REFUSAL OF PLANNING PERMISSION

APPLICATION NO. 2016/1476

Proposal Erection of side and rear extensions to hot food take away.

At 32 Hornby Street, Worsbrough Common, Barnsley, S70 4DA

PROPOSED LAYOUT

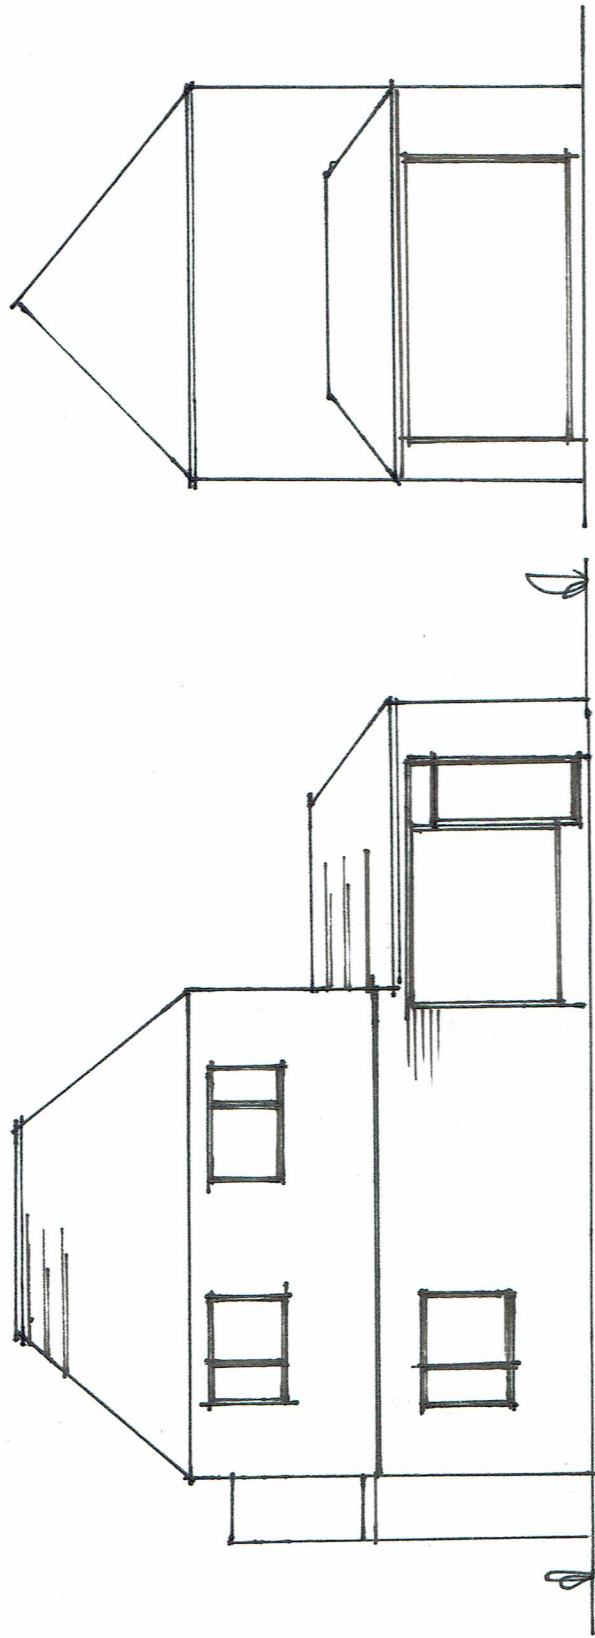
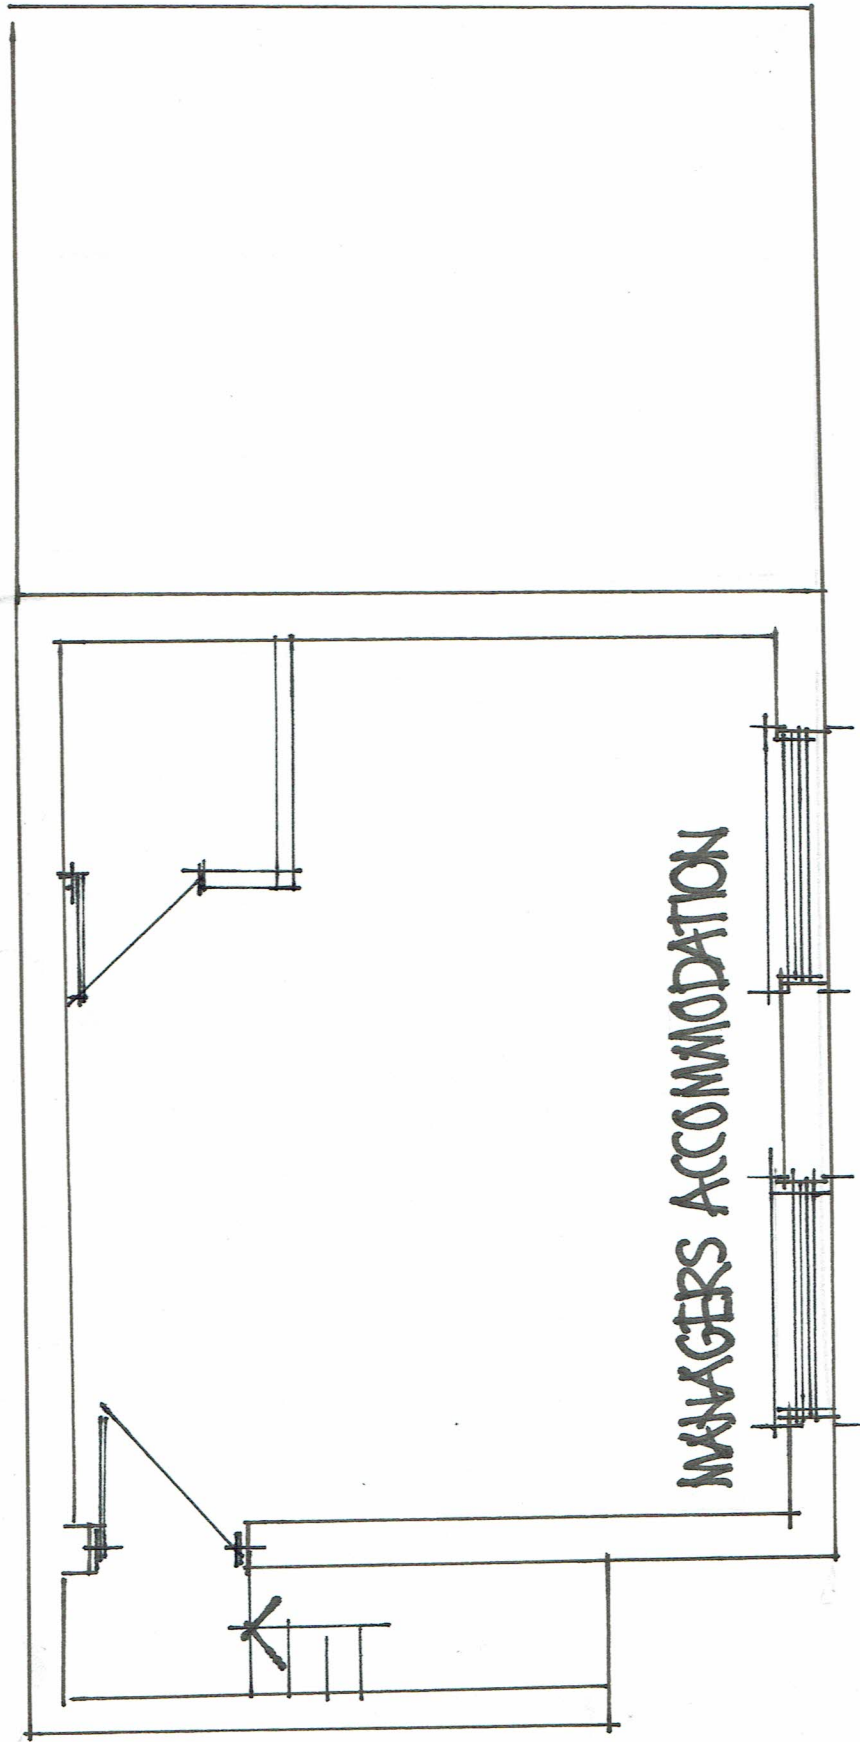
- 3 In the opinion of the Local Planning Authority, the proposed intensification and expansion of the existing use would result in on-street car parking occurring on Hornby Street close to its junction with Highstone Road. Such conditions would be incompatible with the interests of road safety and the free flow of traffic, contrary to CSP 26 and the Council's Supplementary Planning Document 'Hot Food Takeaways'.

ELEVATIONS.

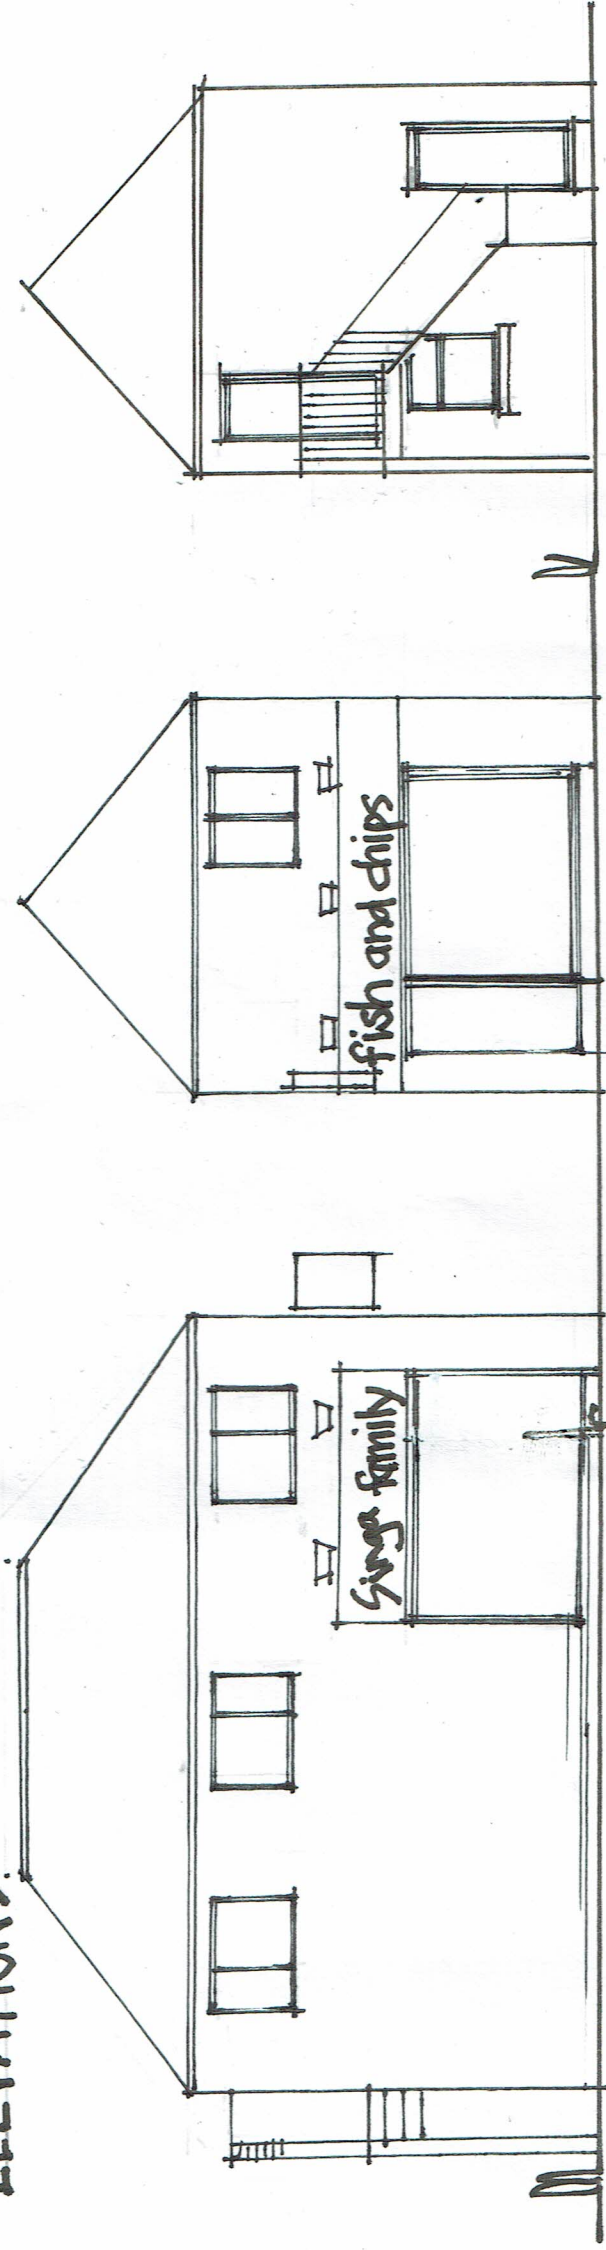
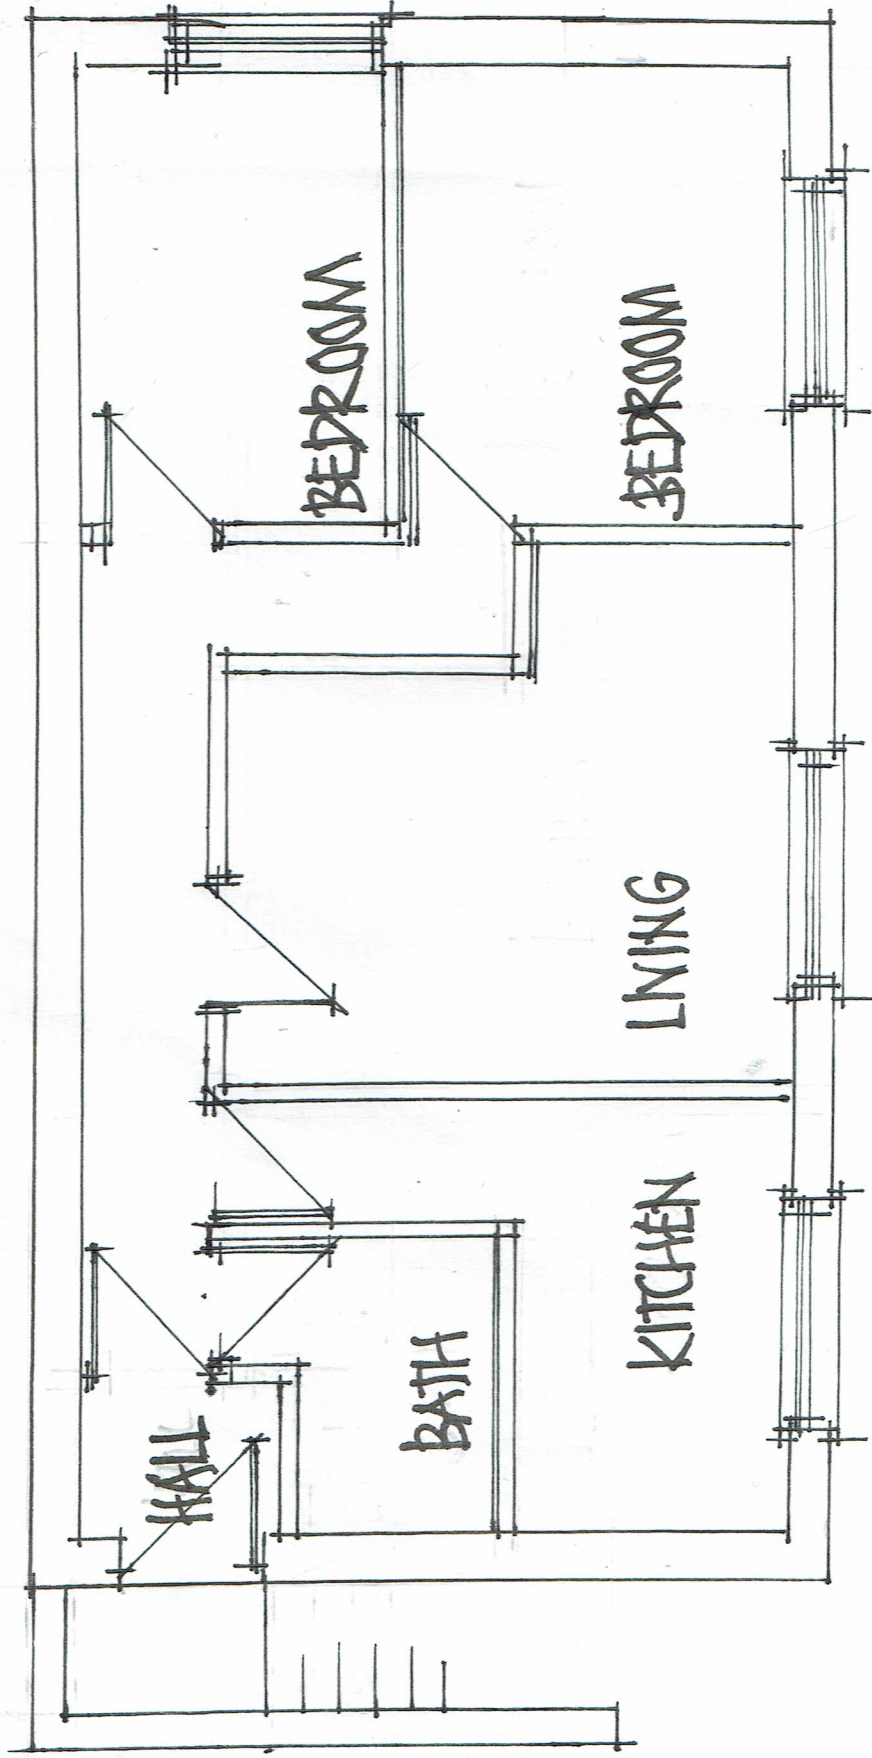
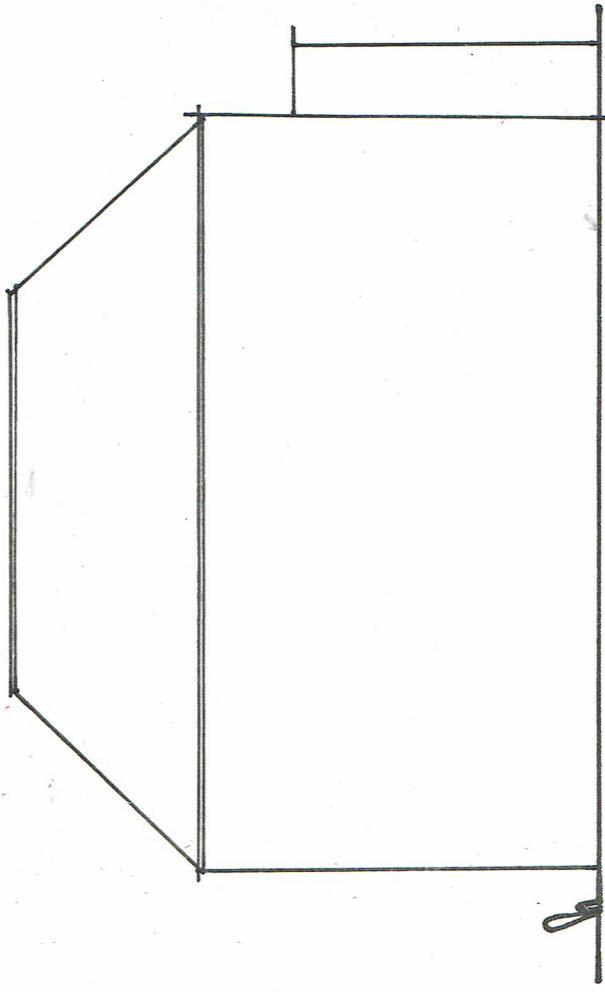
- 1 In the opinion of the Local Planning Authority the proposed extensions and alterations would be contrary to Policy CSP29 in that their size, design and position would be architecturally inconsistent with the character of the host property and neighbouring buildings and would as a consequence appear as an unduly intrusive feature in the street scene to the detriment of visual amenity.
